Application No: FG/155/25/PL

Site Address: Land between 11A The Grove and 30 Brook Lane Ferring BN12 5HZ

Description of works: Erection of 1 No 1-bedroom self build house with associated parking & private outdoor amenity space. This application is in CIL Zone 4 and is CIL Liable as a new dwelling.

Thank you for your internet representation made on 16th January 2026 which has been recorded as an objection with the comments as follows:

A :: Block Plan
01 scale: 1:200

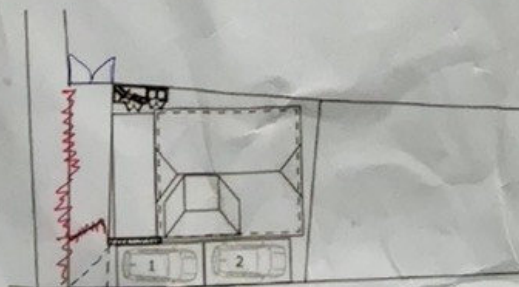
I am extremely concerned that the plans also show a 1.8 meter high fence at the northern boundary adjoining our "right of way" driveway. The plans show that this runs right up to the edge of The Grove. This creates an extremely dangerous junction for us exiting our parking area and joining The Grove as we would have no visibility to our left at this pinch point in the road. This would affect our safety and the safety of other drivers and pedestrians.
